Our ref: OUT26/3931

Subject: Mamre Road Data Centre Campus (SSD-92743706) – Environmental Impact Statement

Detailed advice to DPHI Planning & Assessment regarding the Mamre Road Data Centre Campus (SSD-92743706) – EIS

Appendix C – Stormwater Management Plan (Interim Arrangement)

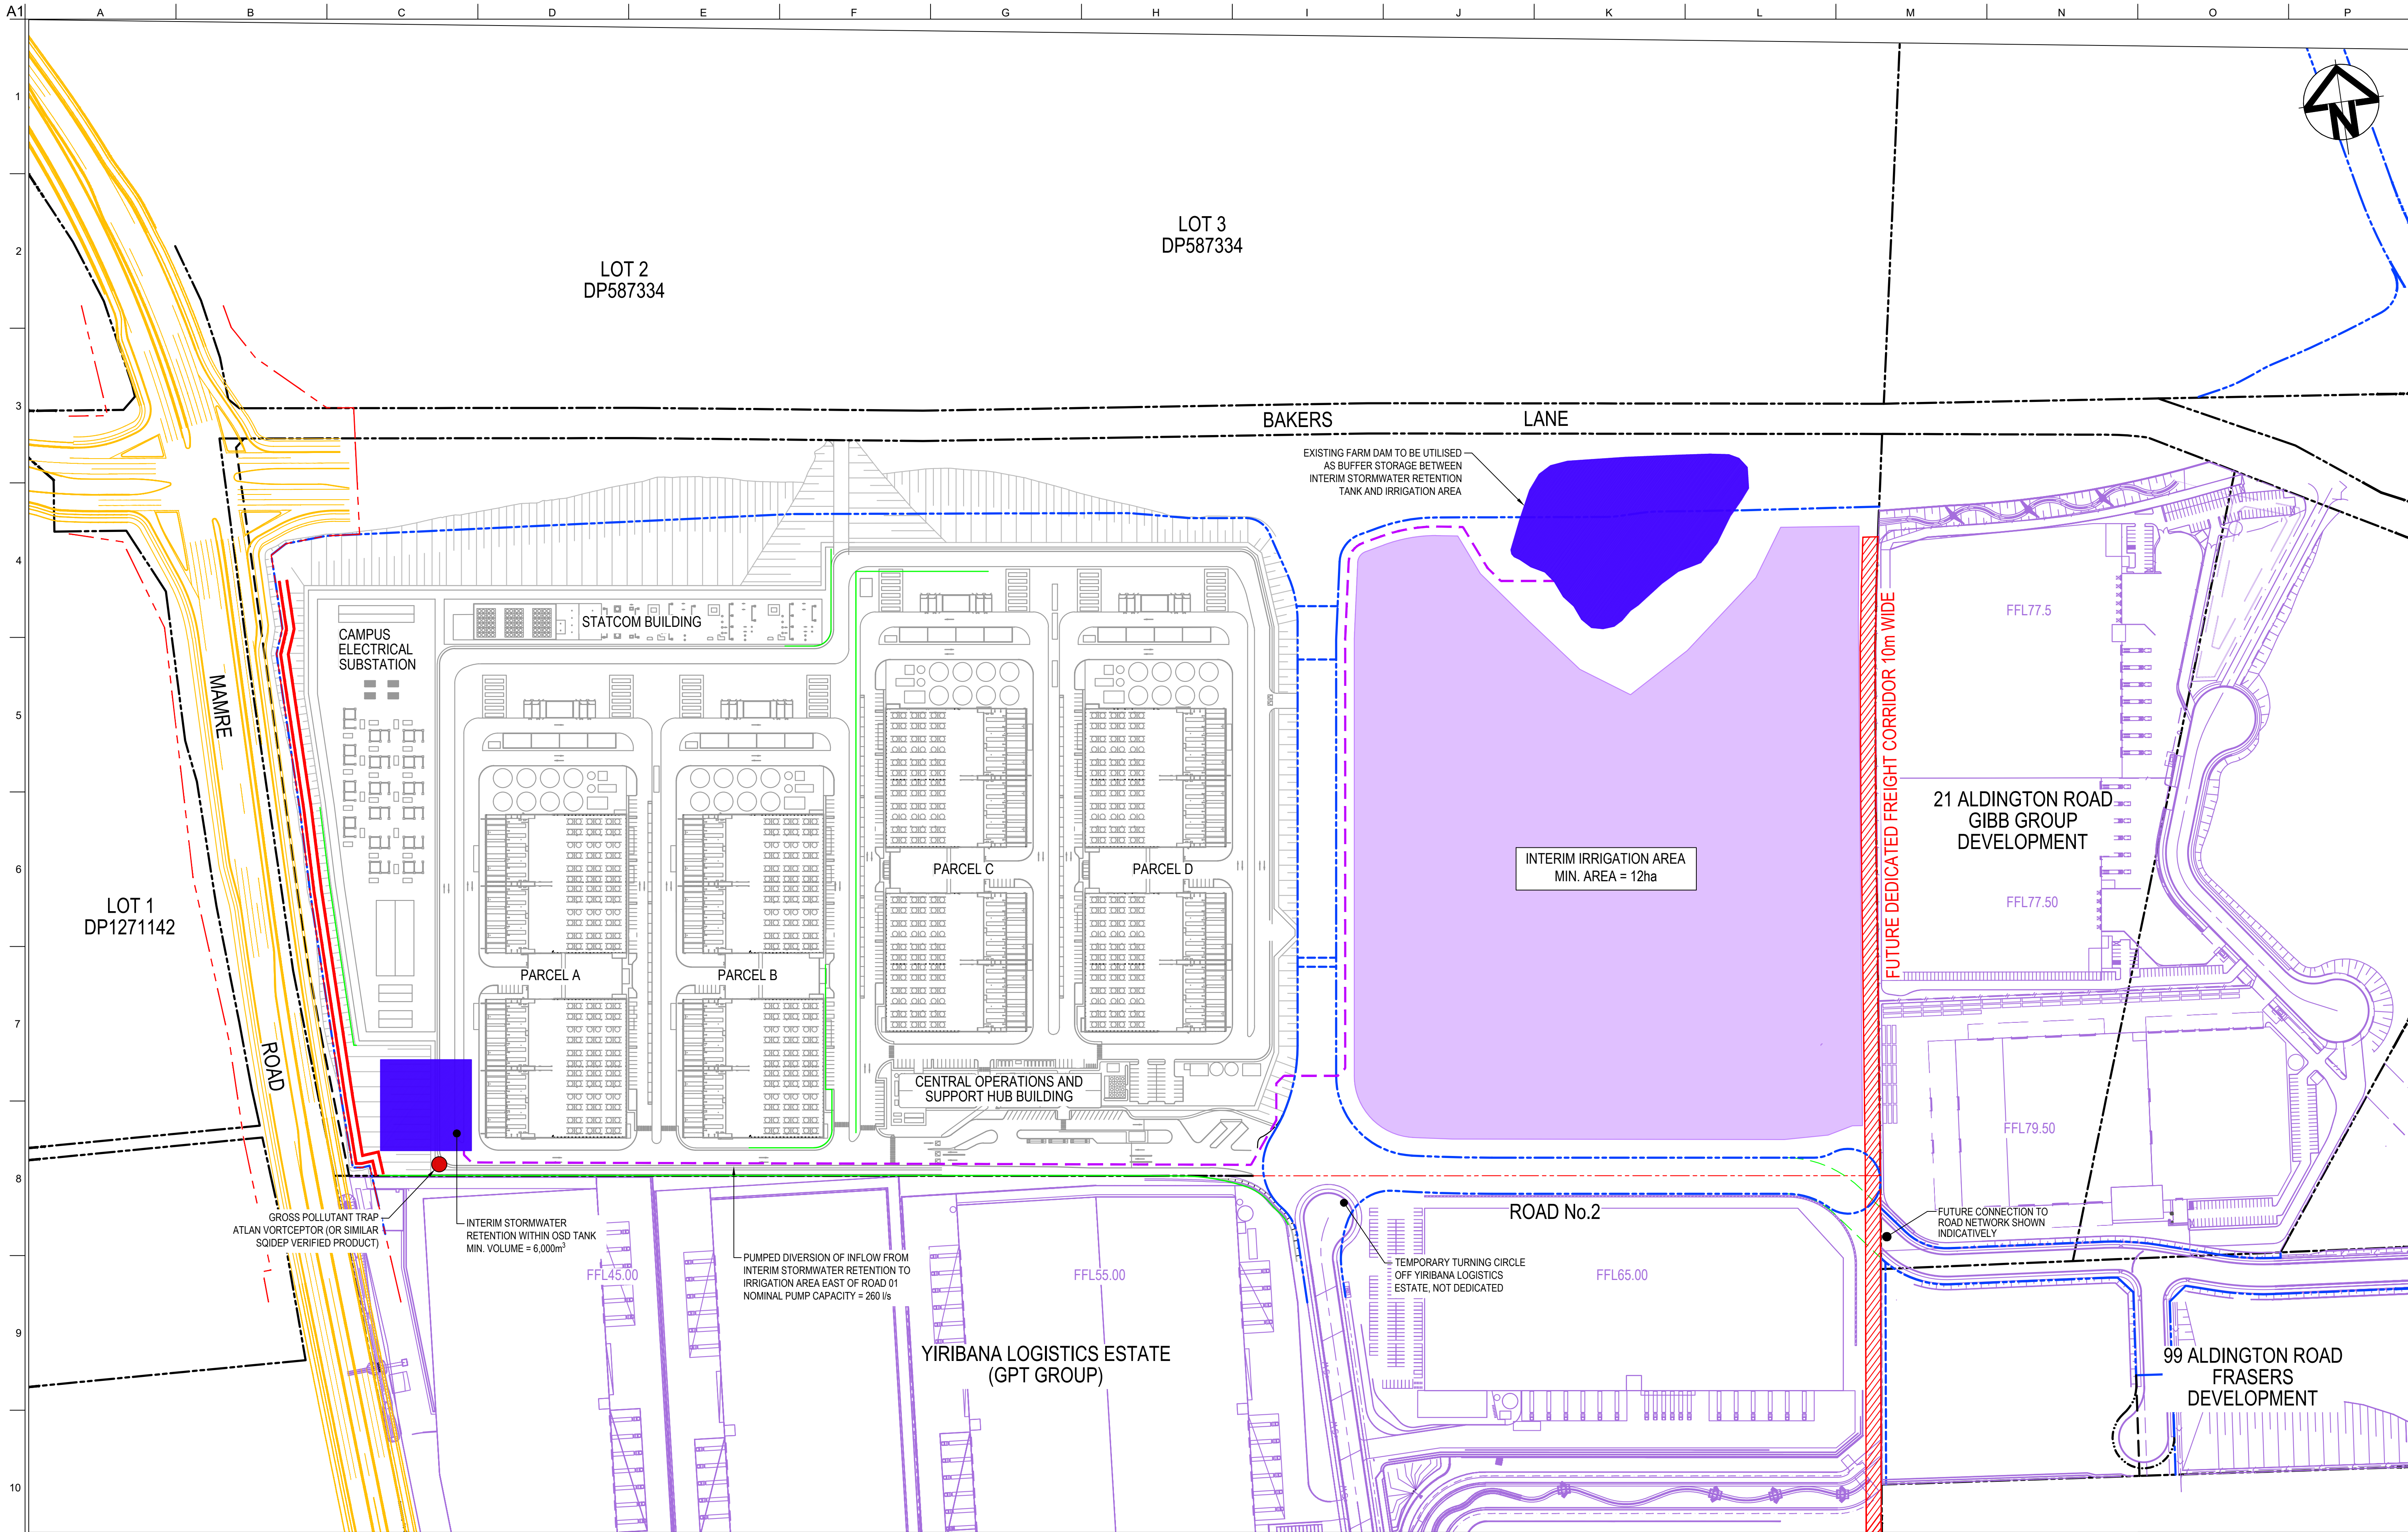
That Department of Planning, Housing and Infrastructure (DPHI) requests the proponent to clarify the interim arrangements to direct runoff from the east of the site into the proposed drainage swale in the north of the site.

Uncertainty exists as to how runoff entering from the east of the site will be conveyed to the drainage swale located in the north of the project site. It is understood a temporary swale is to be constructed on the eastern boundary to convey water to the north, however the flow entry point from the east shown on the Roadworks & Stormwater Drainage Plan - Sheet 6 is located some distance to the south of where the current drainage line enters from. Clarification is therefore requested on the interim arrangements to maintain the flow.
